From: Natalie McKellar [REDACTED]
Sent: 13 July 2021 14:19
To: Neil Crowther <Neil.Crowther@arun.gov.uk>
Cc: Kerry Simmons [REDACTED]
Subject: RE: CM/17/21/PL land at Wren Cottage

Your email to Kerry dated 1st July properties sets out that properties ***'should be 12m from the existing boundary. As advised, this issue would be removed if the properties were 1 ½ storey maximum with no first floor windows facing west'***. Kerry's email response also of 1st July advised that we were in the process of amending the design to alter plots 2, 3 and 4 to 1.5 storey with only high level rooflights at the rear, west elevations.

As such Plots 2, 3 & 4 have all been amended and the layouts altered in order to accommodate your advice. The changes made are as follows:

PLOT 2 FLOOR PLANS
SCALE 1:100 @ a3

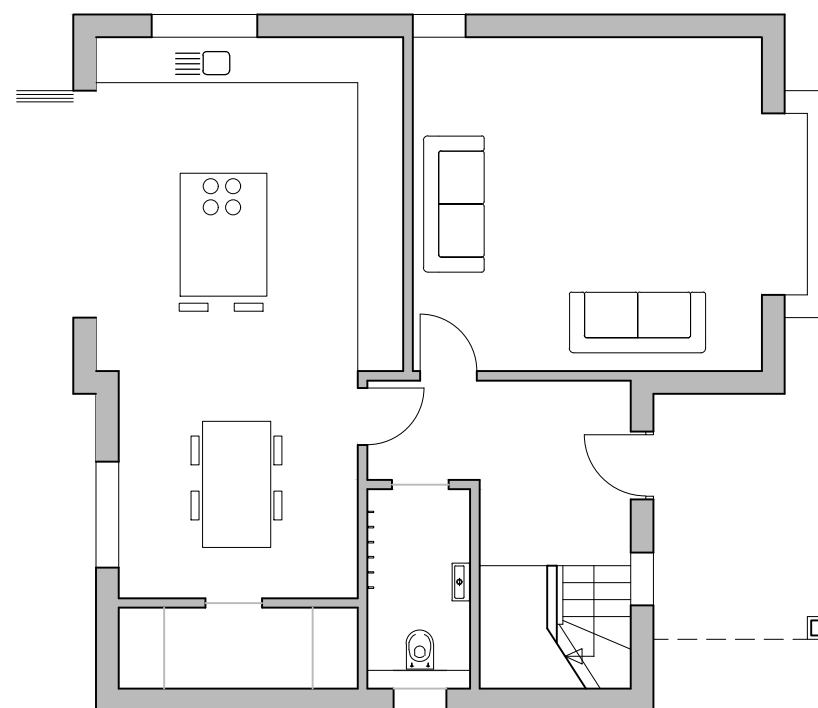
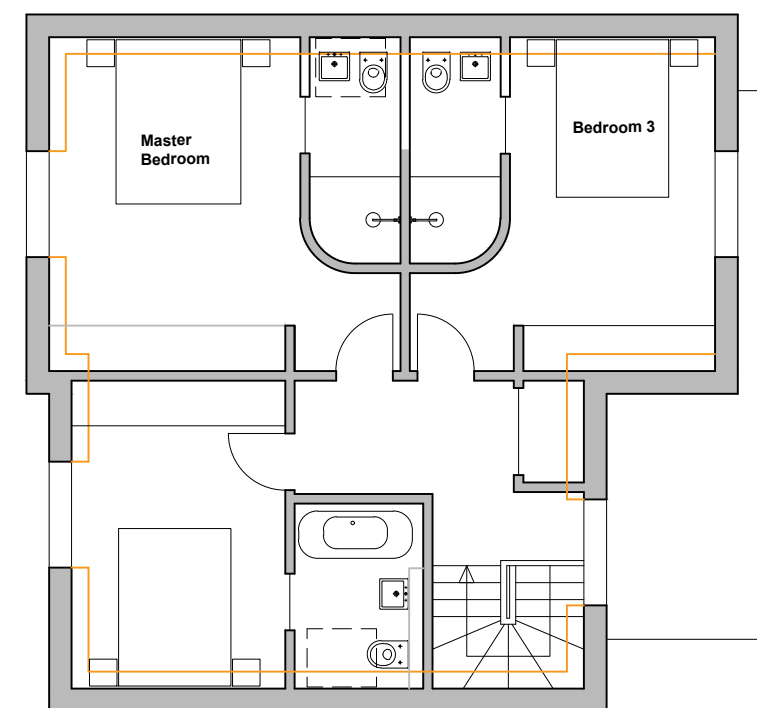
I am very content that the relationship that results from plots 2 and 4 is unacceptable and the proposals would be refused as currently proposed. These back to back distances are unacceptably short.

As the properties to the west are bungalows and you are proposing full two storey dwellings, I consider that the guidance in the Design Guide should be adhered to and properties should be 12m from the existing boundary. As advised, this issue would be removed if the properties were 1 ½ storey maximum with no first floor windows facing west.

There is an issue with what I presume is plot 2. There is insufficient depth to the rear. Part G of The Arun Design Guide which was adopted earlier this month requires :

For the purposes of privacy and to avoid overlooking, the minimum back-to-back dimension should be 21m, provided by rear gardens of minimum 10.5m. Back-to-back distances should be informed by the 25 Degree Rule to ensure proper provision of sunlight and daylight.

Please can you provide details to demonstrate that these plots are compliant. Plot 2 may need to be reduced to a 2 bed dwelling to reduce its footprint and increase its distance to the rear without decreasing the space in front of the property.

No properties are 12m from the site boundary and the relationship is not to two-storey dwellings to the west. There are unacceptable relationships proposed between the proposed and existing dwellings. The distance to the rear of no.5 is only 15.6m and to no.7 only 20m. The distance to no.6 and no. 4 is only 22m – whilst this is marginally above our guidelines, the relationship is a two-storey dwelling to a single storey dwelling and therefore an additional allowance should be included (especially as the properties are not a minimum of 12m from the boundary).

I will be recommending refusal of the proposals as they currently stand. In order for a scheme to be considered favourably, I would suggest that Plots 2 – 4 are proposed without first floor windows to the rear and are significantly reduced in scale so that they are 1 ½ storey maximum height.

Plot 2 has been reconfigured to 1.5 storeys with the third bedroom and en-suite bathroom only to the rear, served by 3 no. high level roof lights at first floor level to the west elevation. It is expected that the windows to the west would be fixed and obscured below 1.7m over finished floor level to prevent overlooking.

I can advise that the applicant is agreeable to amending plot 2 to 1.5 storeys with only high level rooflights in the rear roof slope, given its proximity to the neighbouring property to the rear.

PLOT 4 FLOOR PLANS
SCALE 1:100 @ a3

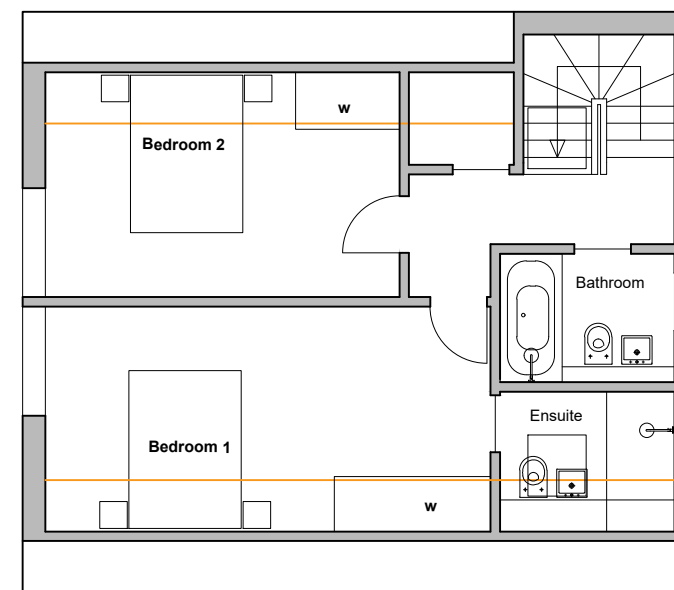
In respect of plot 4(?) Back-to-side distances between buildings should be informed by the 45 Degree Rule to ensure that adequate sunlight and daylight is provided.

Plot 4, which was already 1.5 storey has been reconfigured with bedrooms to the front overlooking the street, and only a fix and obscured bathroom window facing west.
